SSD 6784

SUBMISSION - PARKES SOLAR FARM PROJECT (SSD 6784) PAT MEREDITH DRIVE, PARKES

Thank you for the opportunity to comment on the Parkes Solar Farm Project, involving the construction and operation of a 65 MW Solar Photovoltaic (PV) Plant and associated infrastructure.

Figure 3 Travelling stock route

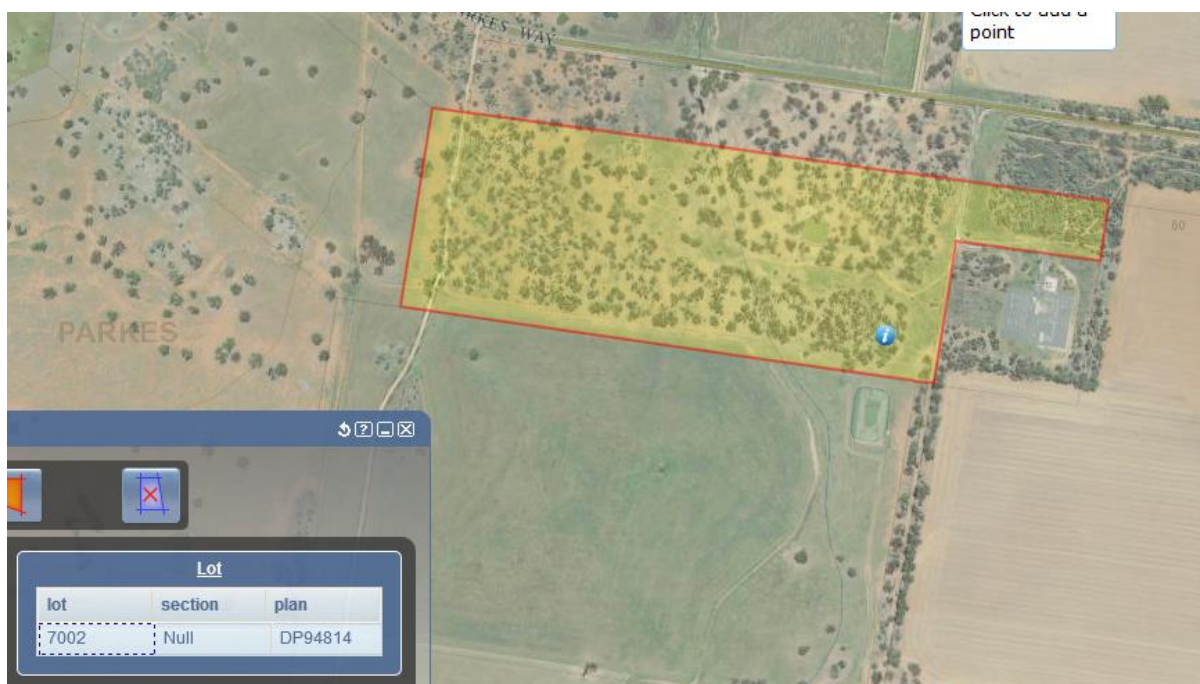
The road reserve of Pat Meredith Drive does not appear to extend all the way to the Henry Parkes Way, and the actual roadway traverses a Travelling Stock Route / Crown Land (Lot 7002 DP 94814). It is necessary to create a road reserve along that section of Pat Meredith Drive that traverses the Crown Land.
